Plan
1 : 50

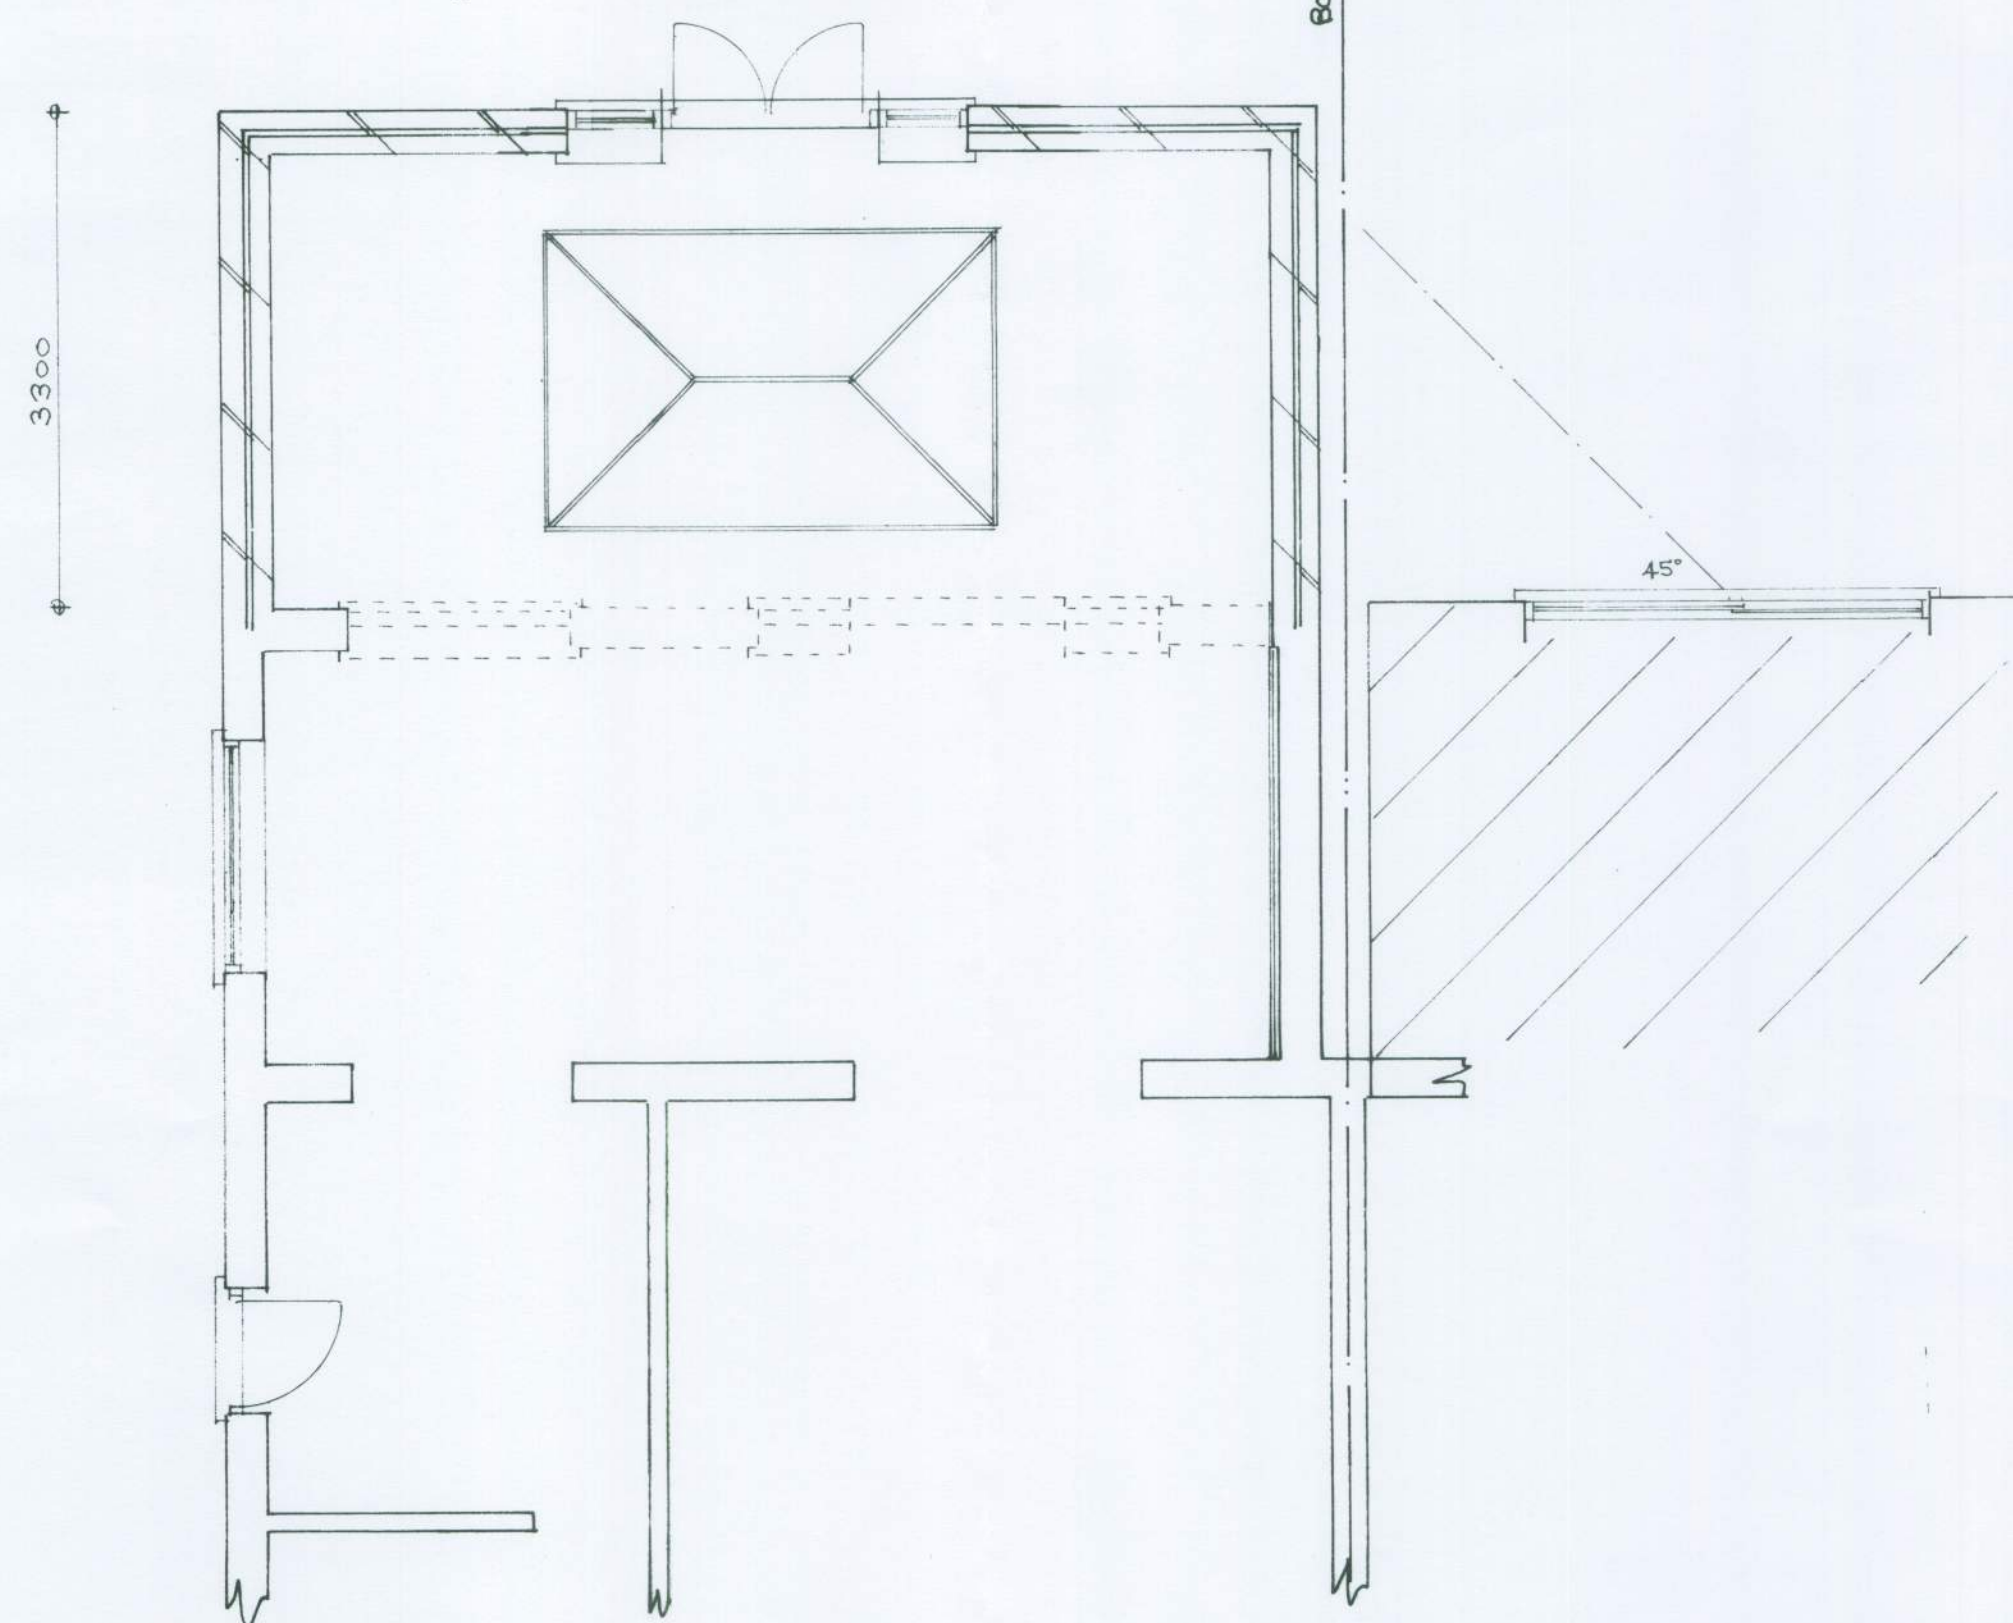
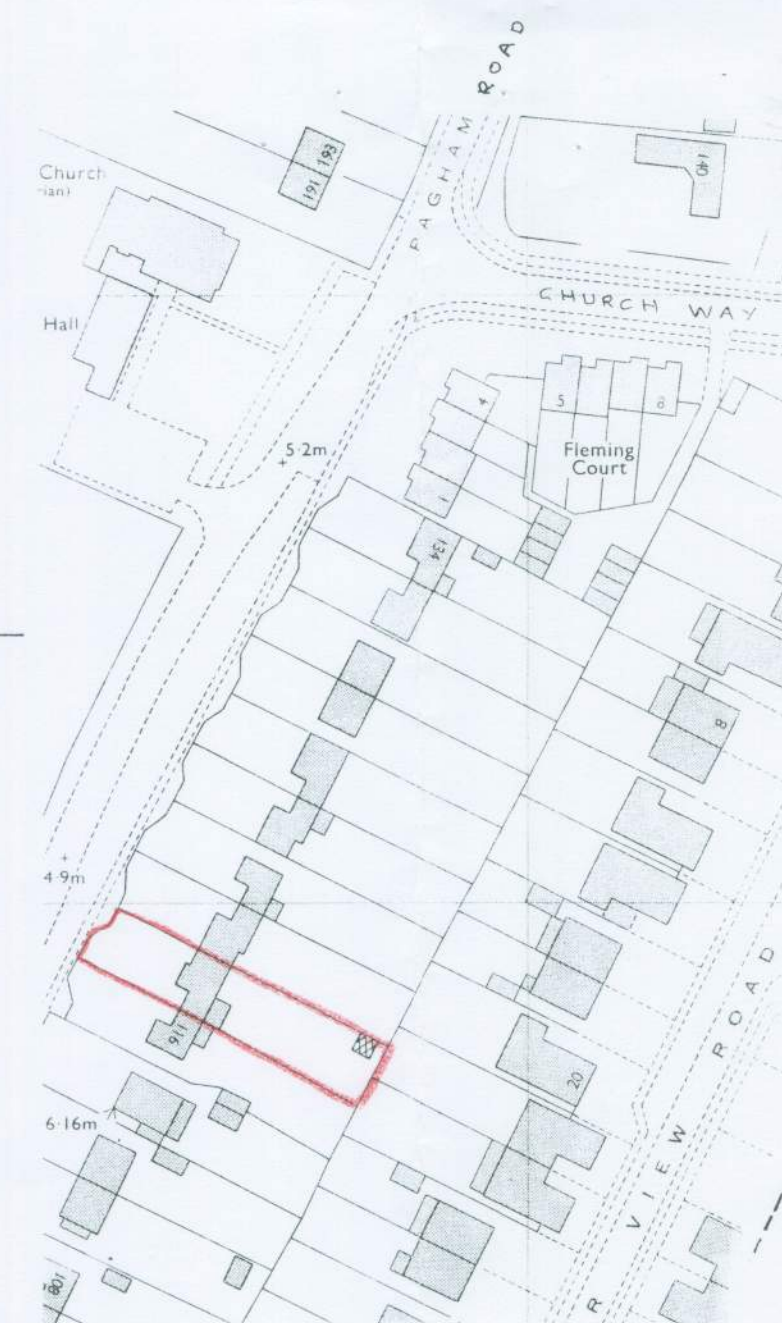
- 1/. From the drawings that I have seen, the applicant is proposing to build up to the boundary. I am responsible for that boundary, and require that I am able to keep it maintained.

- 2/. In the same vain, Mr Cooper will also need to keep his building properly maintained. I have recently approached him with regard to this, and he agreed to leaving enough room (65 Centimeters from the boundary) to allow for said maintenance without needing access to each others property.

- 4/. There is also the problem that he is intending to build within 1 Meter of the Soakaway for my flat roof, which on my plans states "Soakaway 15 ft from any building" See P/117/82BR 20-09-1982.
It would also mean that he would also be building over the Soakaway of his own ground floor extension added later to his property.

- 6/. There is also the question of rain water run off. His first floor extension added a huge area to the roof.
This has been connected into the down pipe for the original 1956 Soakaway, which is now under the floor of his House.
There seems to be no mention of how the run off from this latest extension roof will be got rid of, as I believe we are not allowed to dispose of it down the local sewers.
